HTE #: ERES2102-0066RR

EXISTING SEPTIC SYSTEM INSPECTION

Property Location (State Road name and #): 562 HARVELL RD (SR 2008)

Purpose of Inspection: 22 GROUND MOUNTED SOLAR PANELS - DRAINLINES MARKED ONSITE VIA GPR - REVISED TO MEET SEPTIC SETBACKS - SITE PLAN SHOWS TRENCHING GOING AROUND SEPTIC AREA - DO NOT CROSS SEPTIC AREA WITH POWER SUPPLY

SHEET NAME
PLOT PLAN & VICINITY MAP

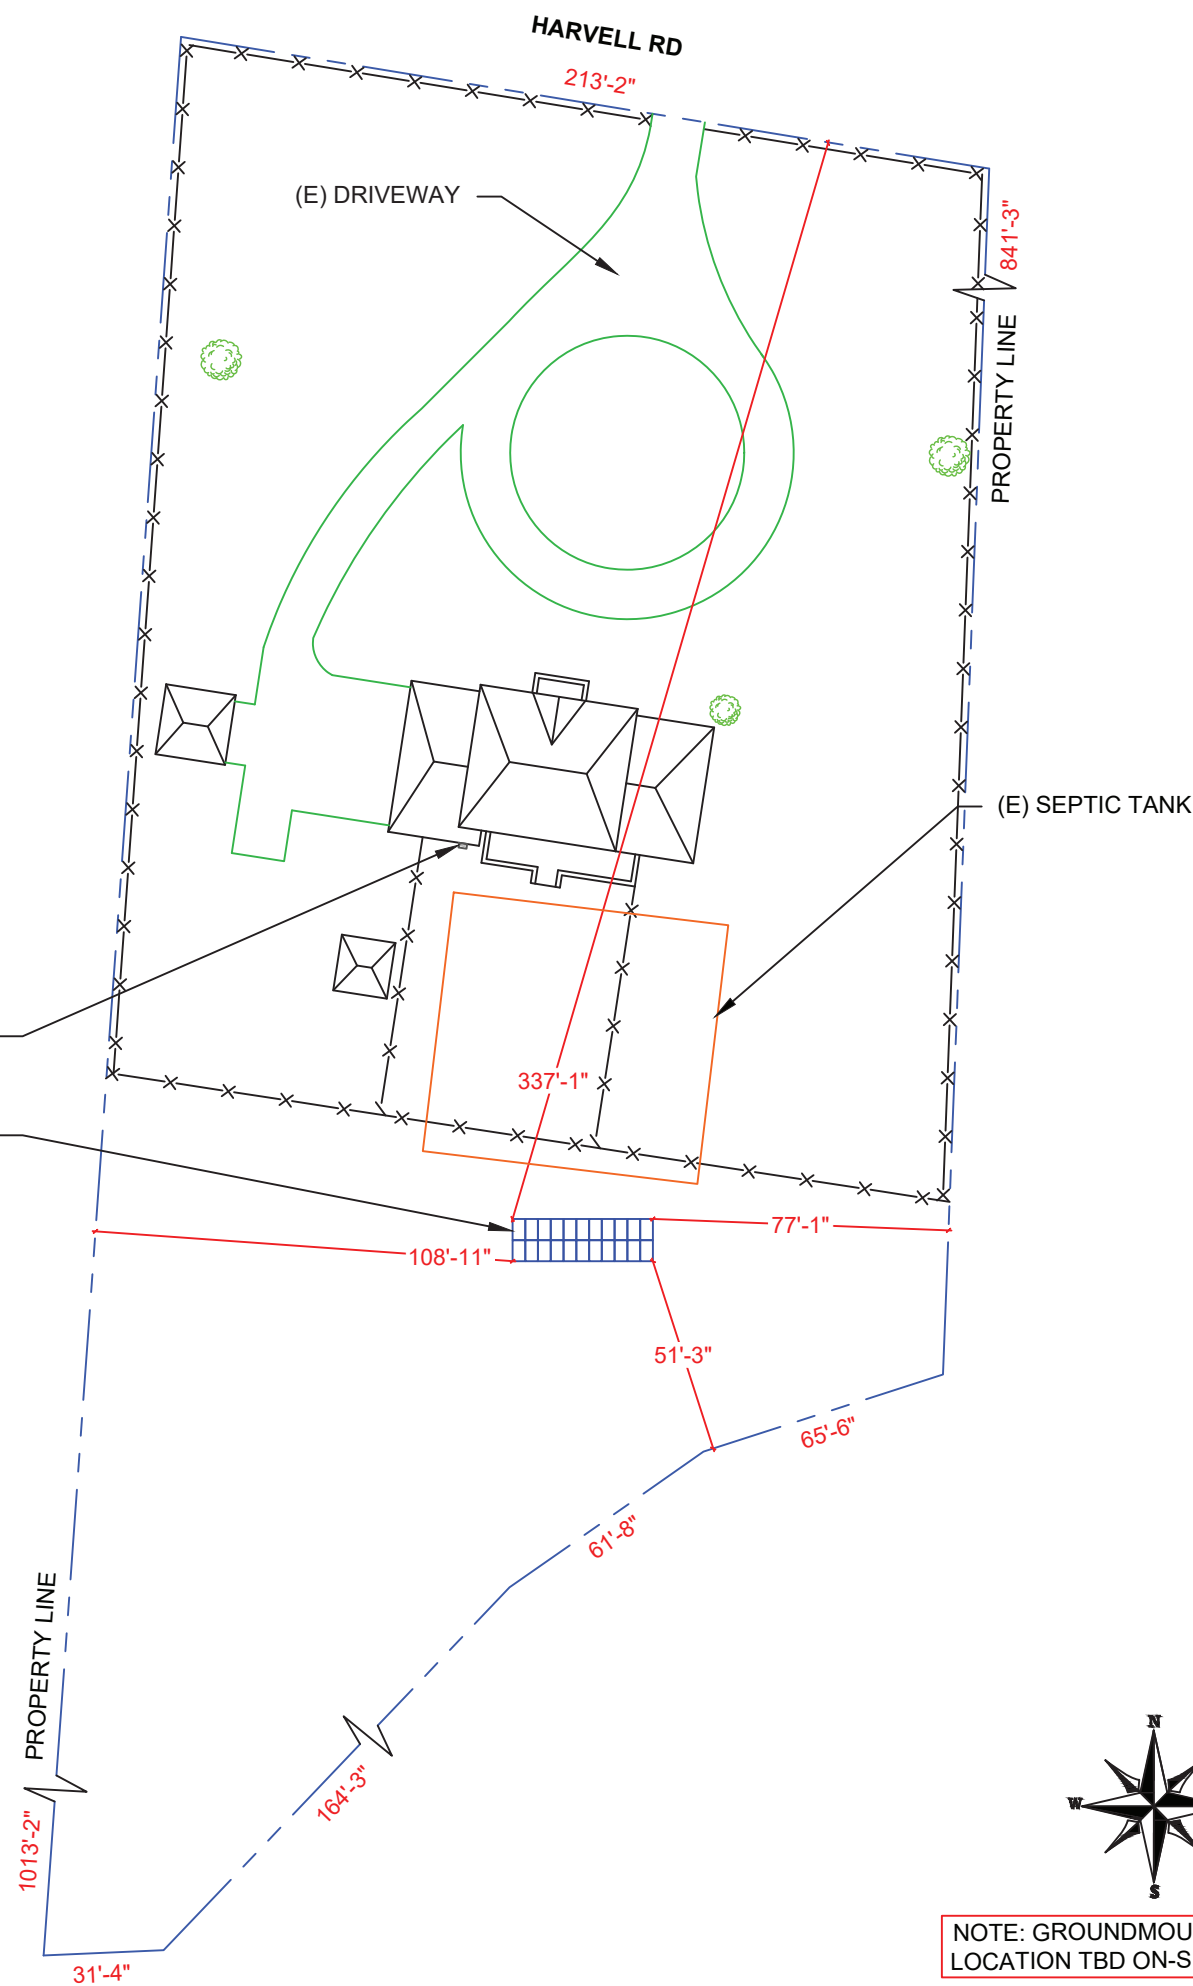
**BUILDING MUST BE 5' FROM ANY PART OF SEPTIC SYSTEM
DO NOT DRIVE OR PARK ON SEPTIC SYSTEM**
